TO	Nicole Brewer, Director, Energy Assessments
FROM	Mark Davey
DATE	17 July 2026
OUR REFERENCE	0617753
SUBJECT	Keri Keri Wind Farm (SSD-3858962) Request for Additional Information

Keri Keri Wind Farm (SSD-3858962)–Request for Additional Information

Ref No	Theme	Submission	Response	Where Addressed
TfNSW-01	Traffic (generation)	1. Preconstruction Minor Works for workers accommodation camp traffic assessment requirements. A complete assessment of the wind farms and workers' accommodation camp construction pre-construction minor works is required and is to include: - Assessment of traffic volumes and identification of the types of vehicles that will be used during this period, including the largest design vehicle. - Perform a swept path analysis for the largest heavy vehicle at the existing intersection, ensuring it can navigate within the current pavement. If the design vehicle cannot turn easily, implement necessary mitigation or temporary works. - Assess existing Safe Intersection Sight Distance (SISD) and propose measures to achieve compliance, - Identify AM/PM peak hour traffic volumes and proposed volumes during this time. Traffic volumes during the AM/PM peak hours are to be c

Keri Keri Wind Farm - OSOM Routes 1A/1B/2A/2B
KM Index 83.0/158.0: Sturt Highway / Market Street, Balranald
Strategic Concept Design

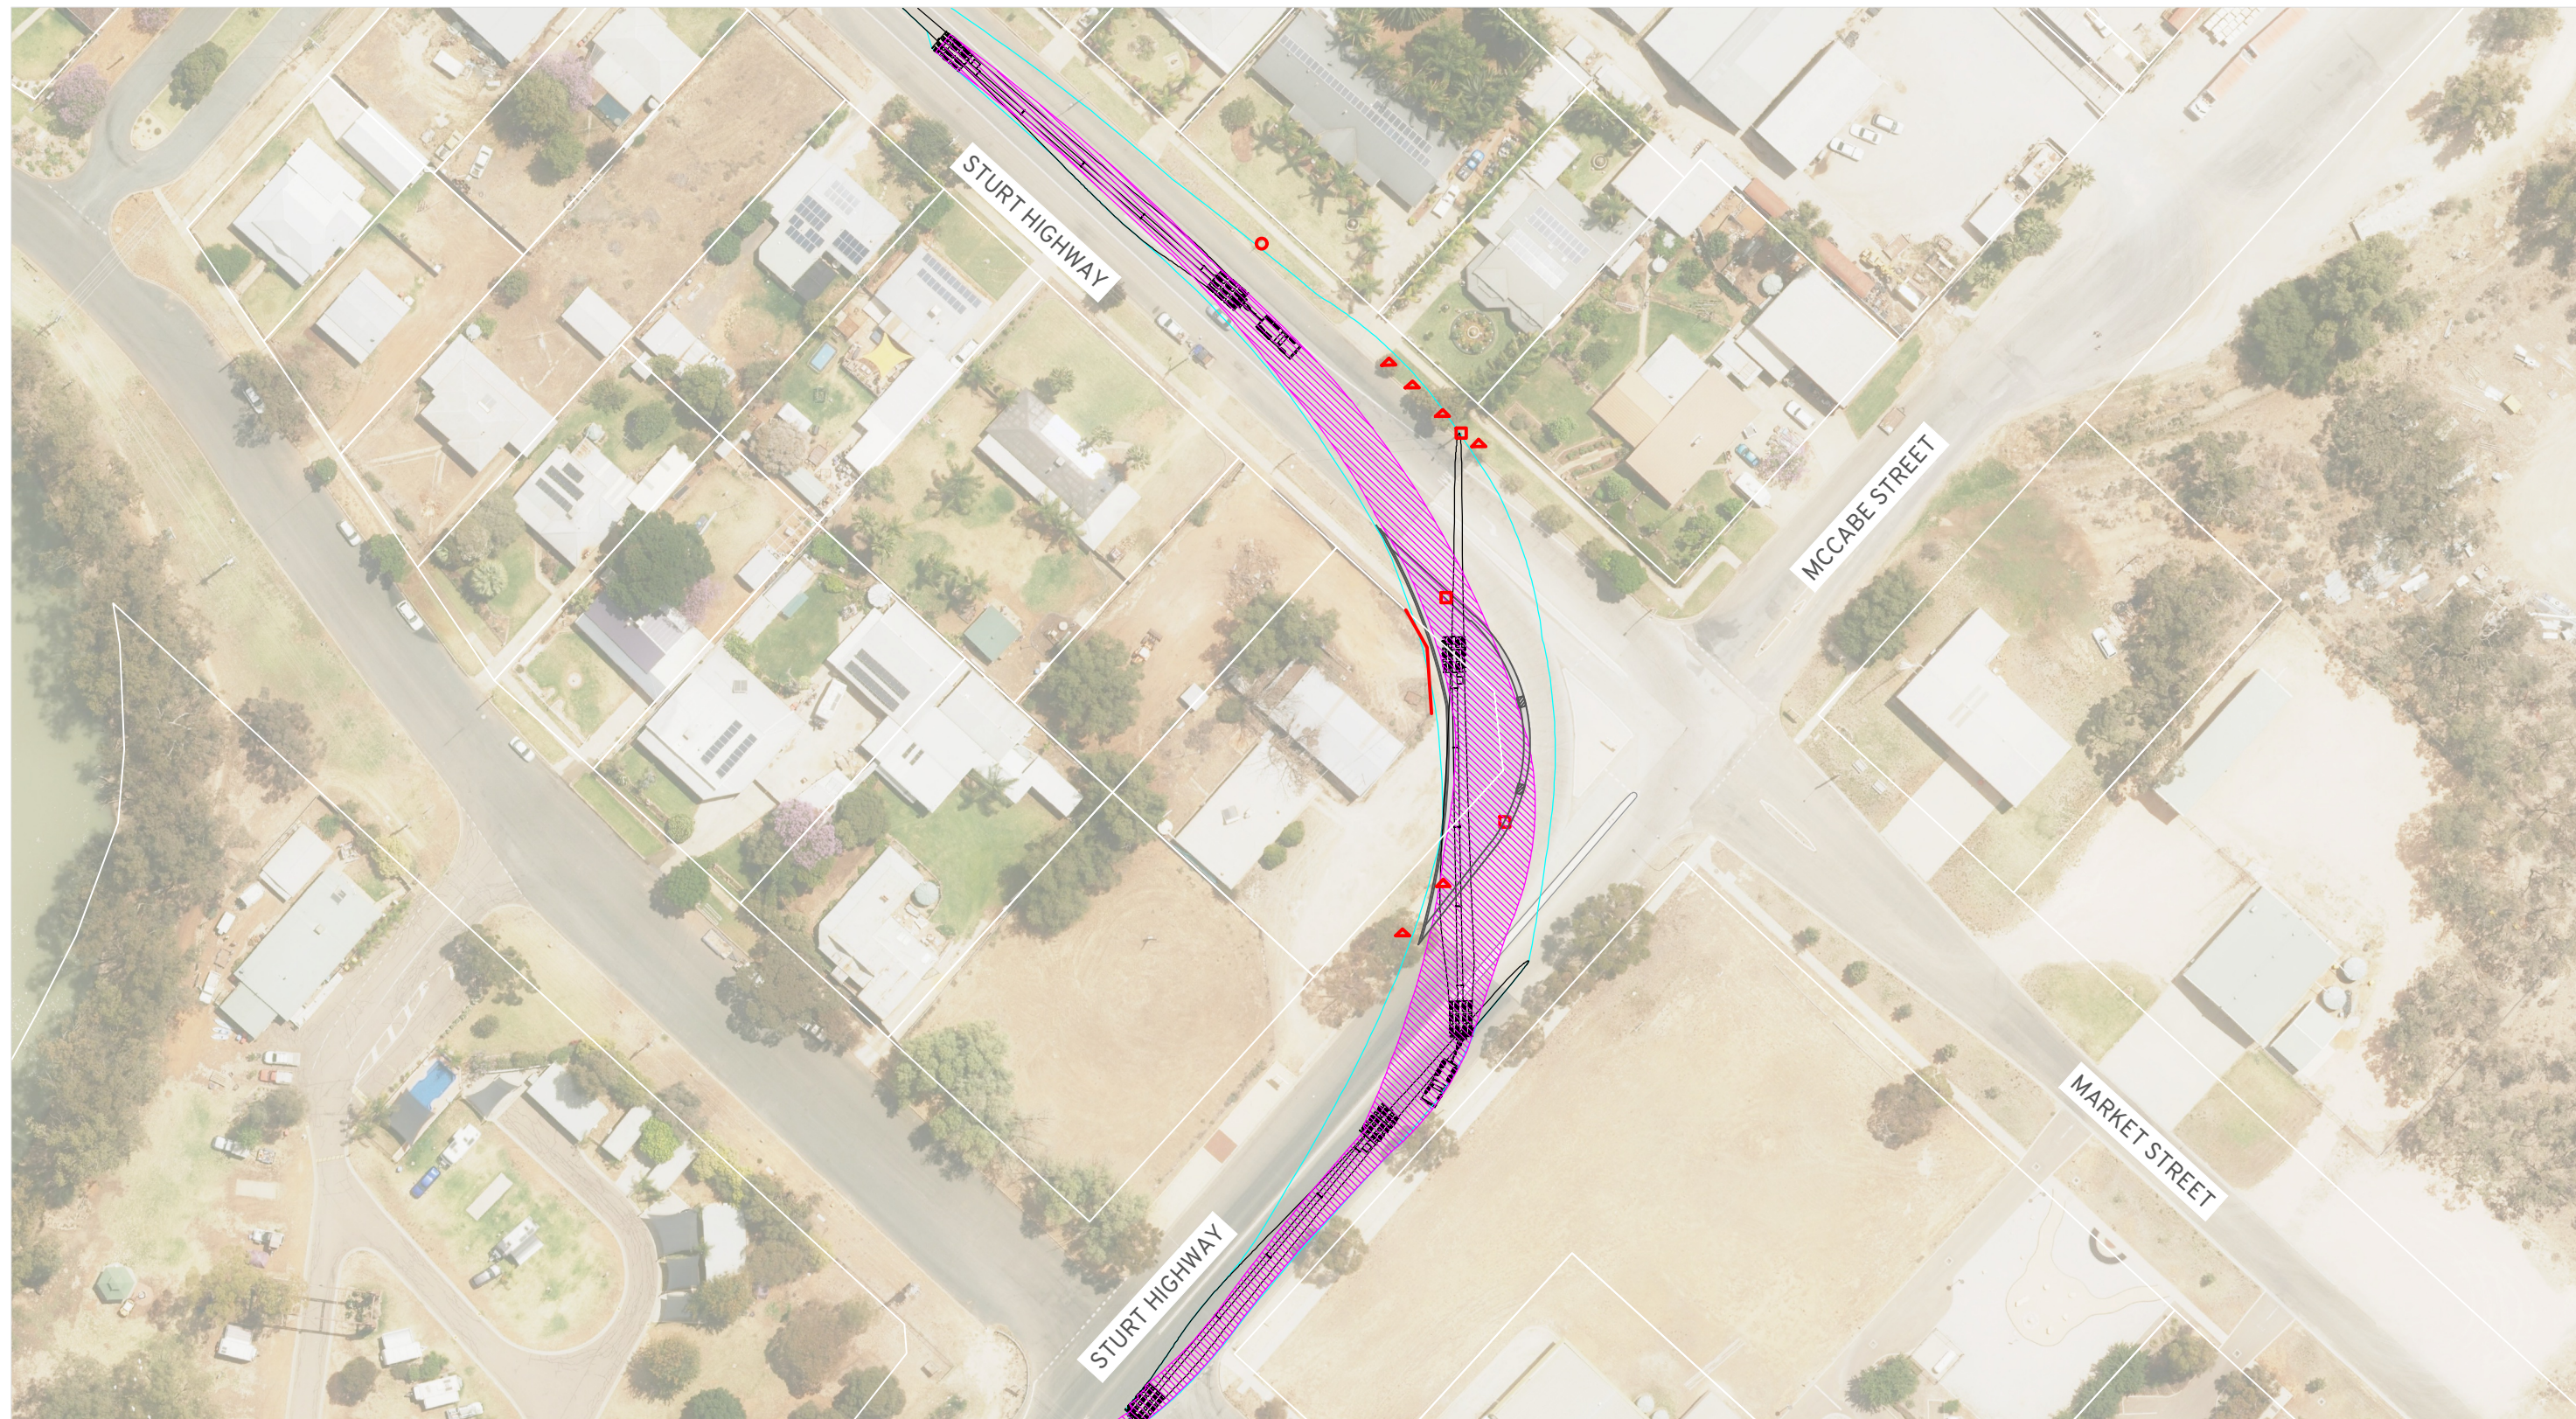
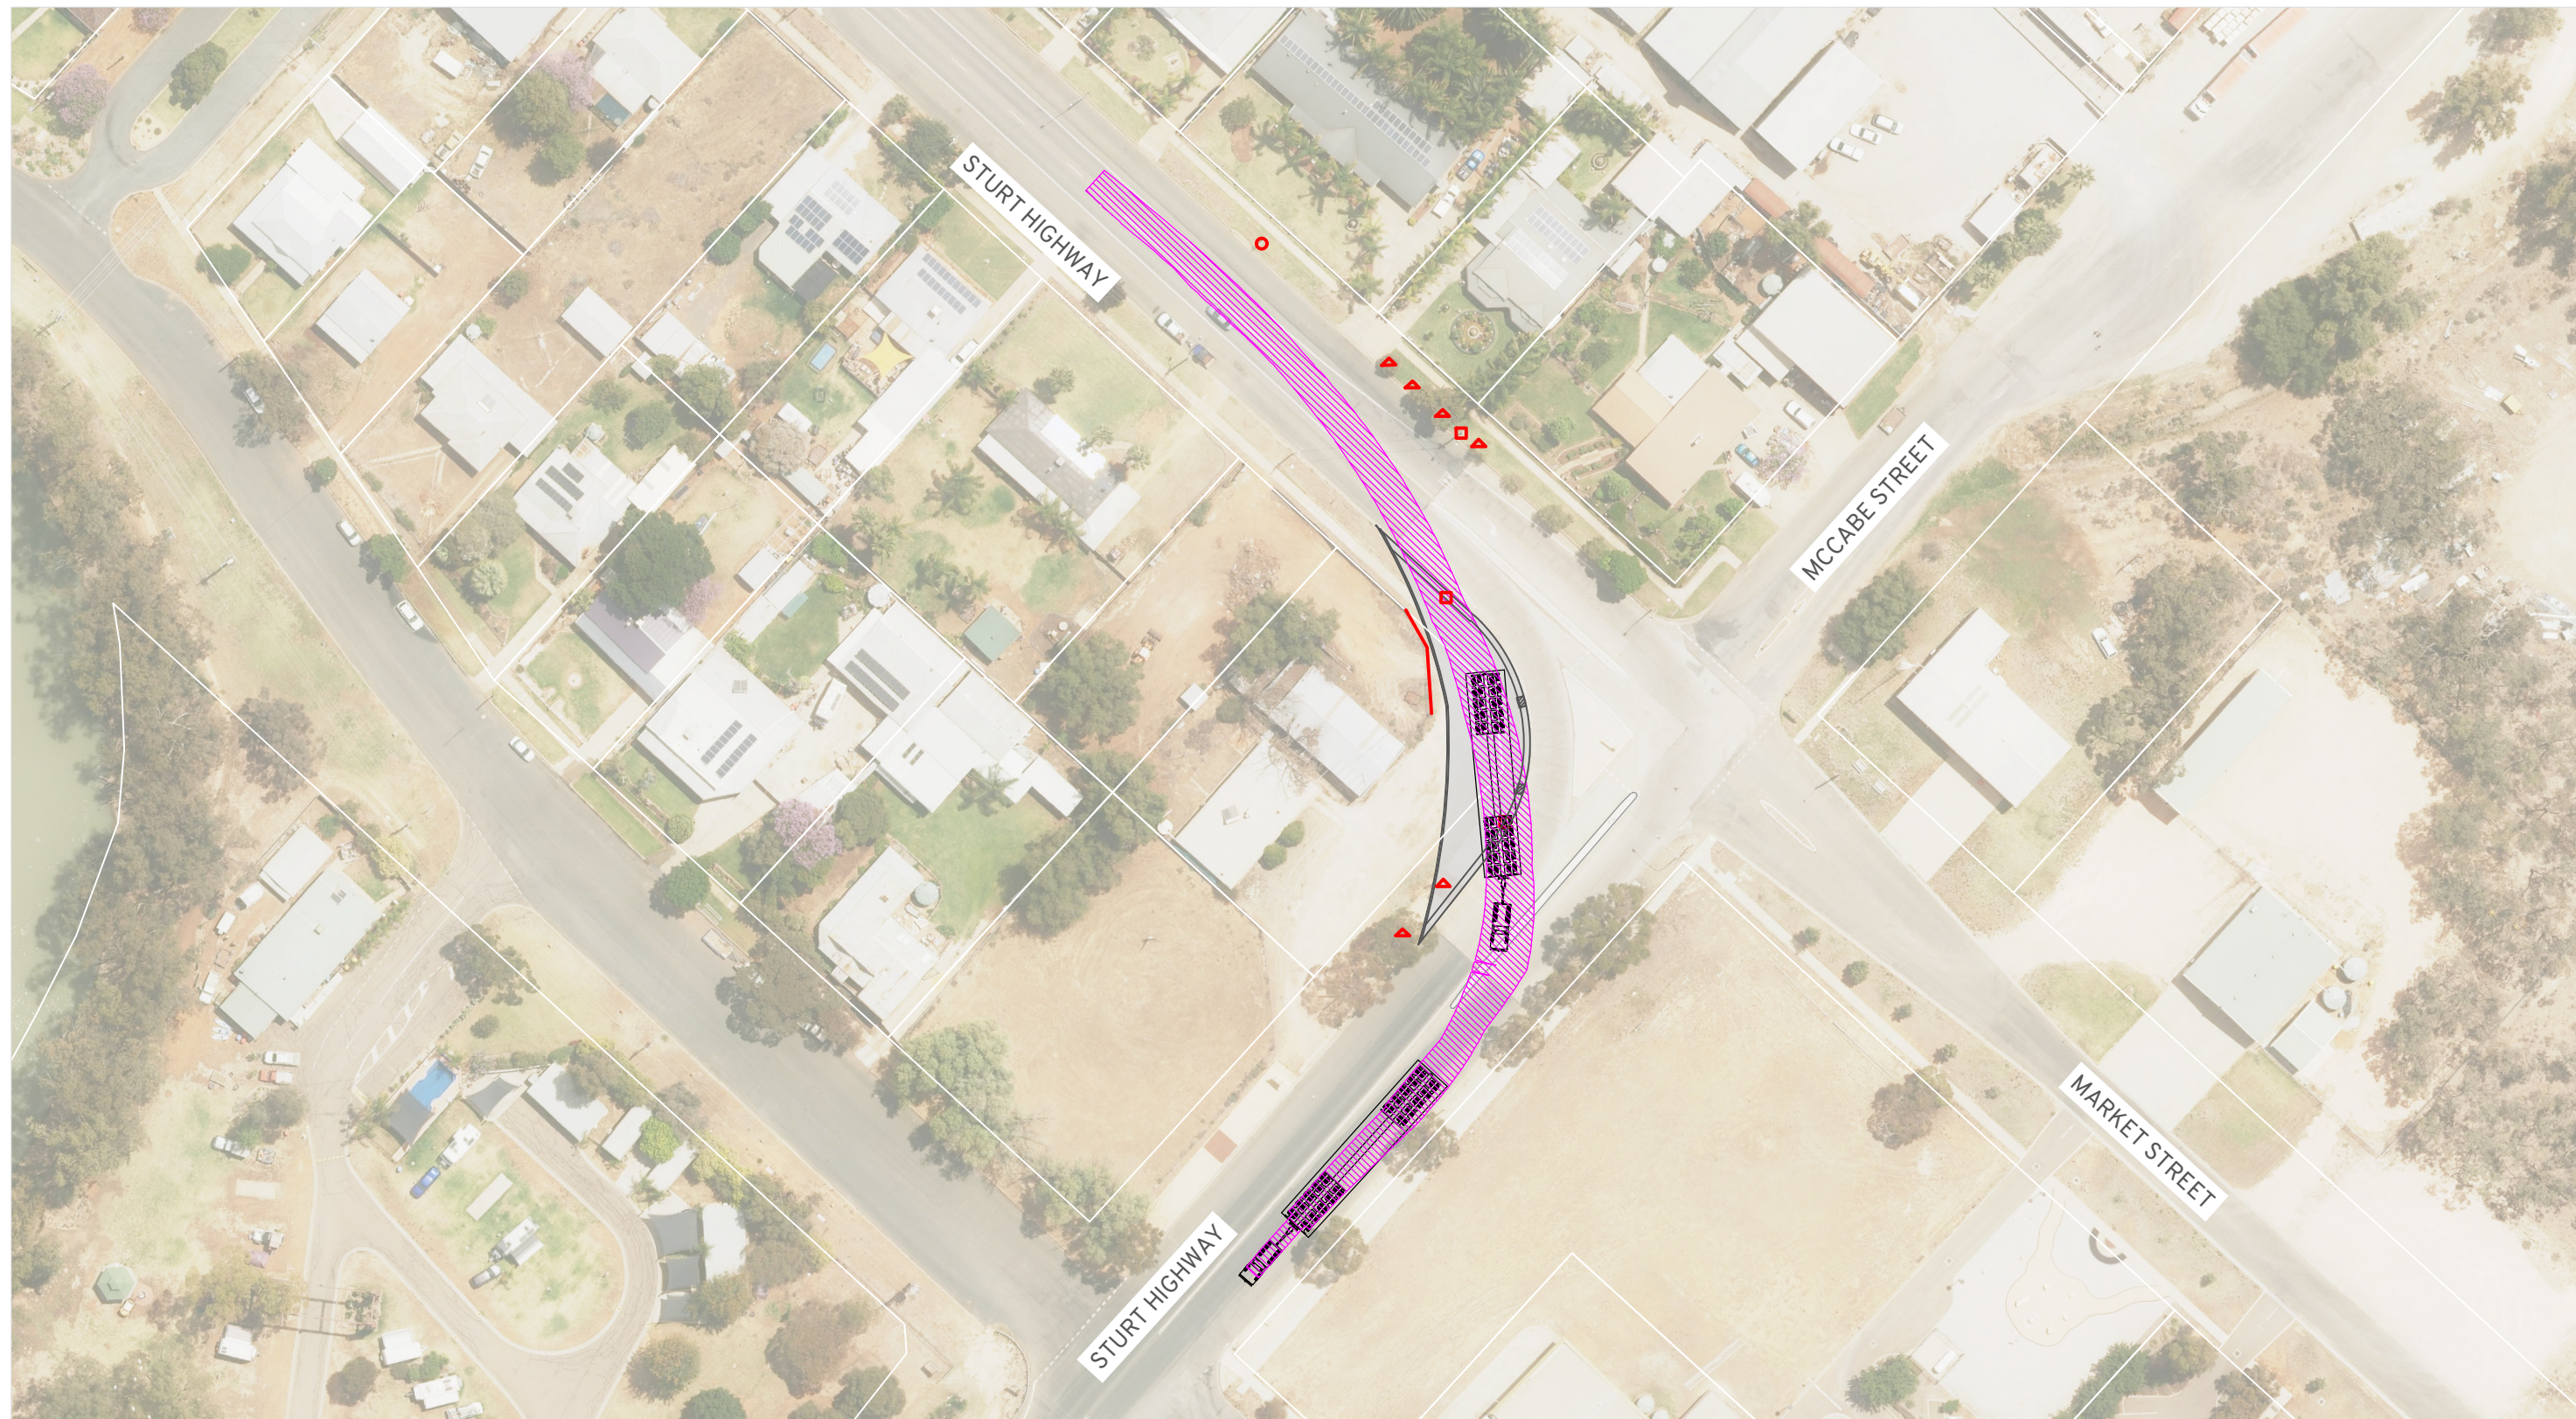
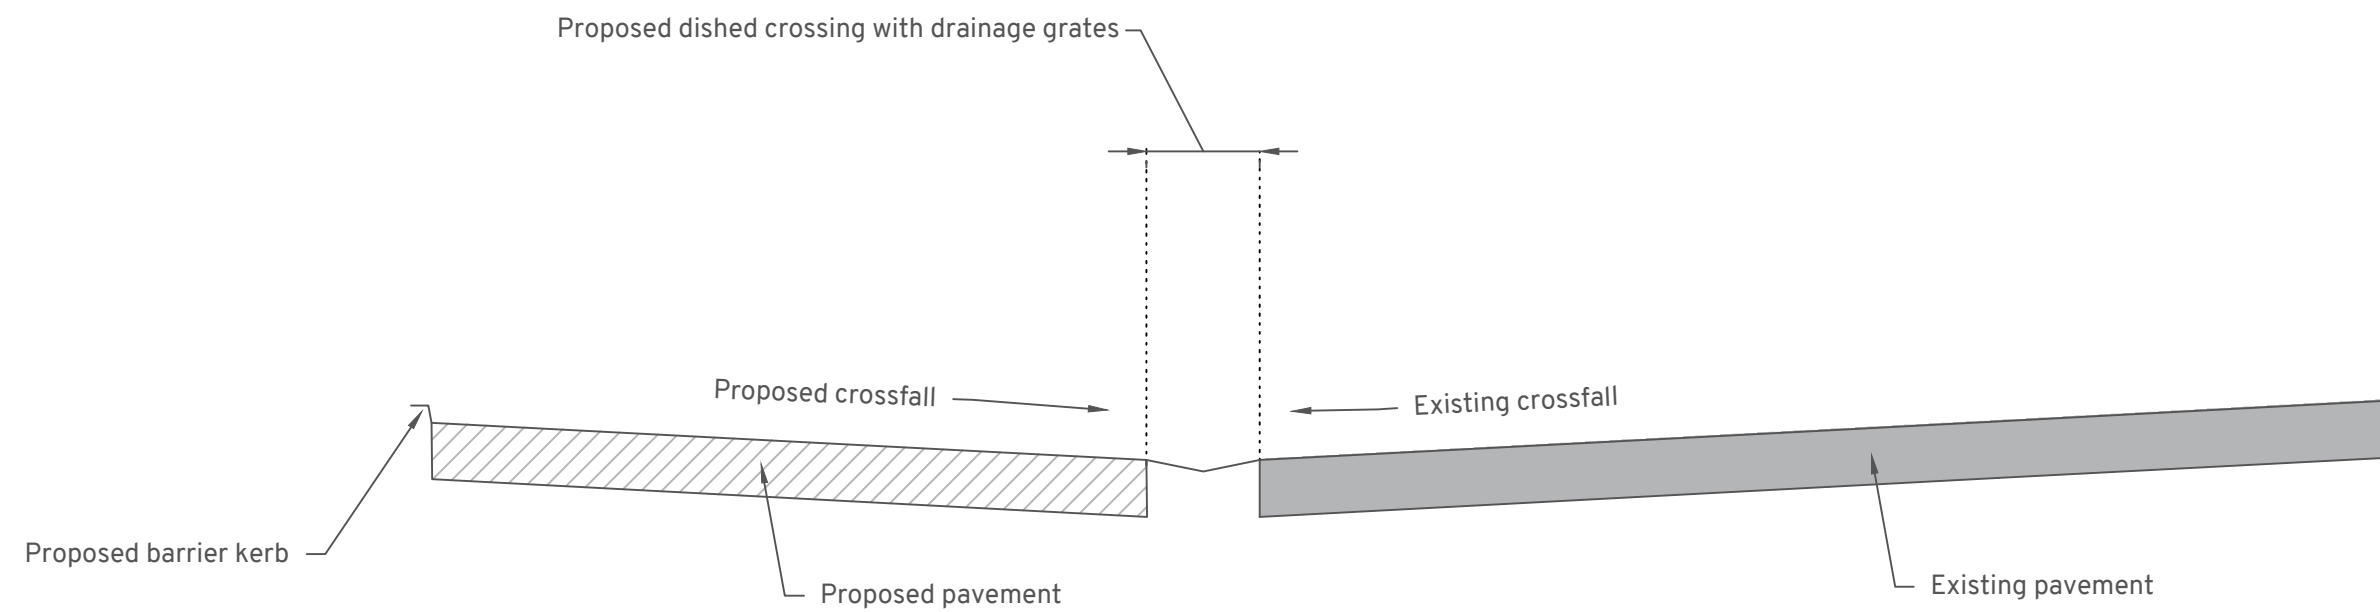
c. Revision D, Civil Design, RJ Andrews SPA - Sturt Highway at Balranald - TfNSW preference is to maintain the current intersection configuration with medians and kerb and channel. Revised strategic concept designs required that references to the barrier kerb be removed and replaced with a roll-over kerb to facilitate movements onto the hardstand. d. Drainage pits will need to be assessed and made trafficable as required. To be annotated on the strategic concept designs.	Revised strategic concept design for this intersection is provided in Appendix A (Sheets 04-07). The design includes a dish crossing with trafficable grates to facilitate movements onto the hardstand area.	Appendix A (sheets 04-07) of the Amended TIA (Attachment D)

j. Revision D, Civil Design, 21012CAD003 Figure 5 - TfNSW preference is to maintain the current intersection configuration with medians and kerb and channel. Please replace the barrier kerb with a roll-over kerb to facilitate movements onto the hardstand. Drainage pits will need to be assessed and made trafficable as required. - Where the raised island is proposed to be removed, TfNSW's preference is to retain this island and make parts of or the whole length trafficable.	Revised strategic concept design for this intersection is provided in Appendix A (Sheets 04-07). The design includes a dished crossing with trafficable grates to facilitate movements onto the hardstand area, as well as strengthening of the impacted traffic island.	Appendix A (sheets 04-07) of the Amended TIA (Attachment D)
